[BL-11-00024 Otte](#)

RE: Otte Boundary Line Adjustment, BL-11-00024

MEMORANDUM

TO: Jeff Watson, CDS
FROM: Christina Wollman, Planner II *CW*
DATE: June 28, 2013
SUBJECT: Otte BL-11-00024

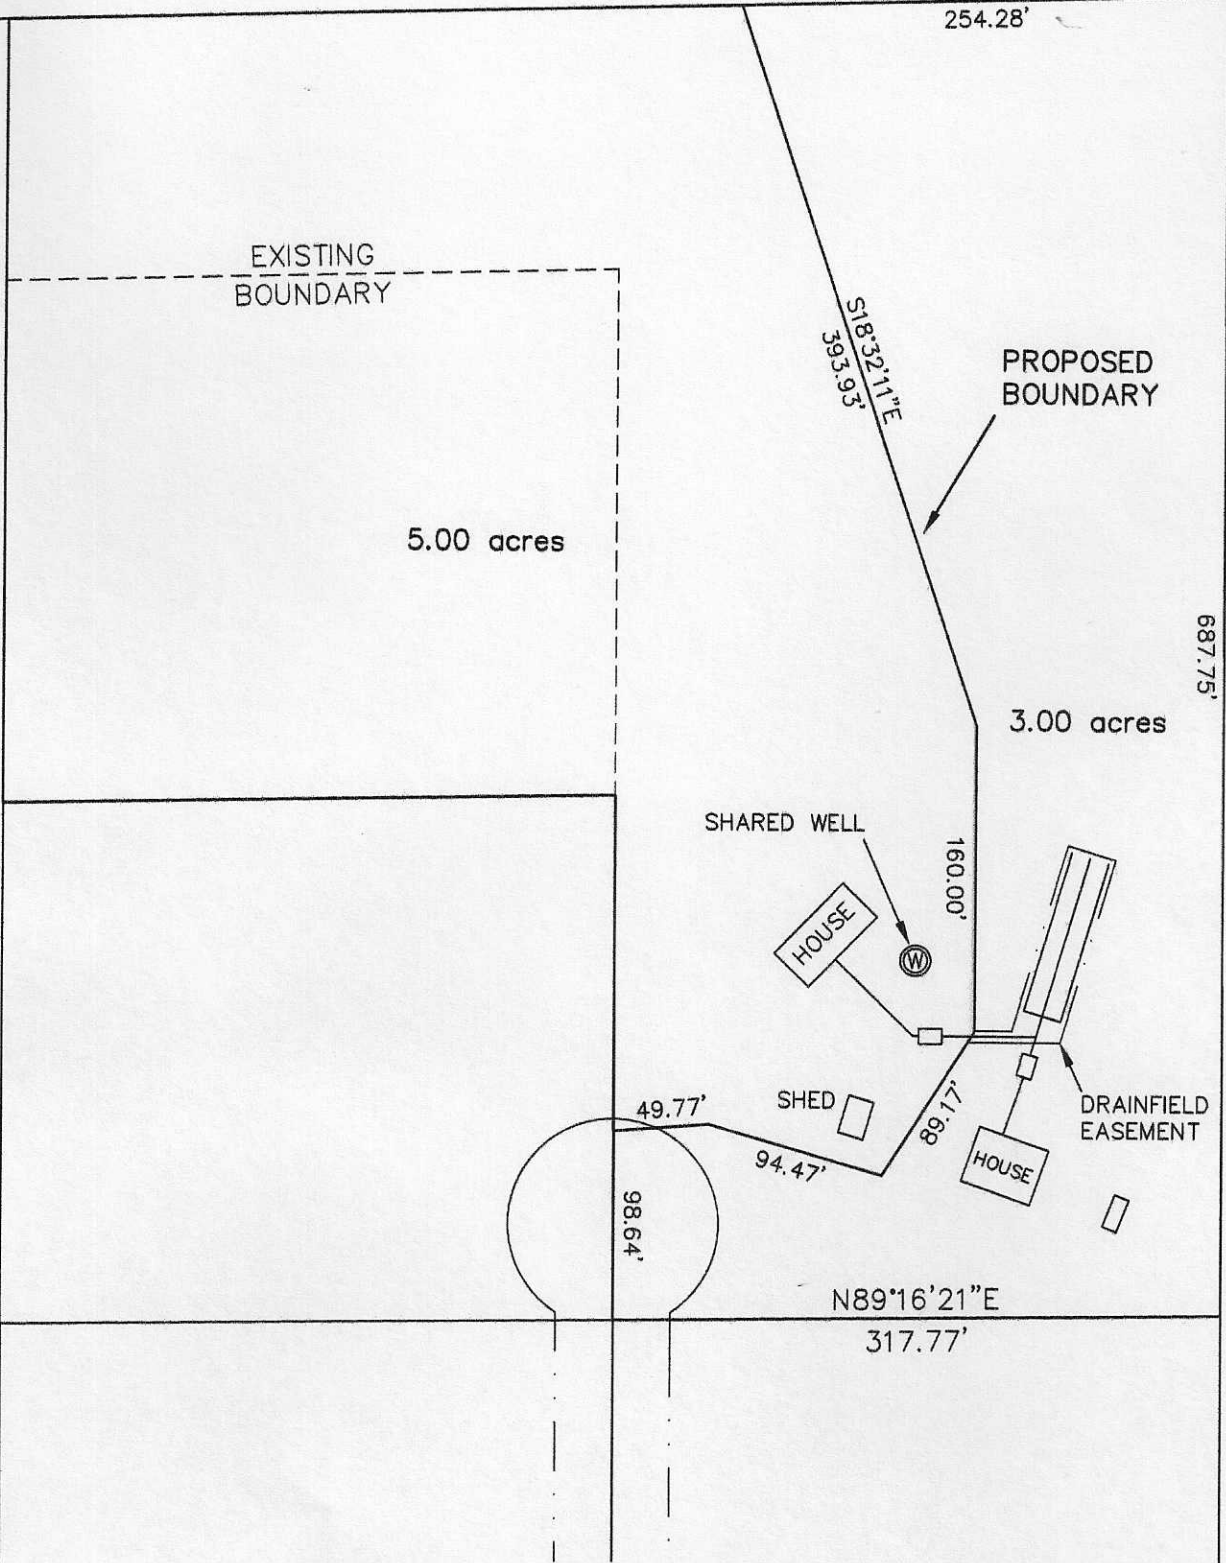
Since this is a shared well between the two lots the 50 foot setback from the property line is not an issue. I am not sure how the drainfield got within the 100 foot radius.

50 feet. The existing well isn't even 100 feet from the existing drainfield.

I also have questions on this one. It appears that the proposed project will have a lot line going through the area where the house, well site and drainfield might be. I need a better site plan showing the location of the well and on-site sewage system in relation to the proposed lot line. Can the applicant provide this?

This took a little while but the attached exhibit shows the existing utilities and where both parties would like the revised boundary to end up. Currently there is one well and one drain field that serves both residences. They have agreed to share these utilities and can record the necessary easements and shared well agreements once they have received the conditions for final approval. Please review and contact me back with any questions or concerns.
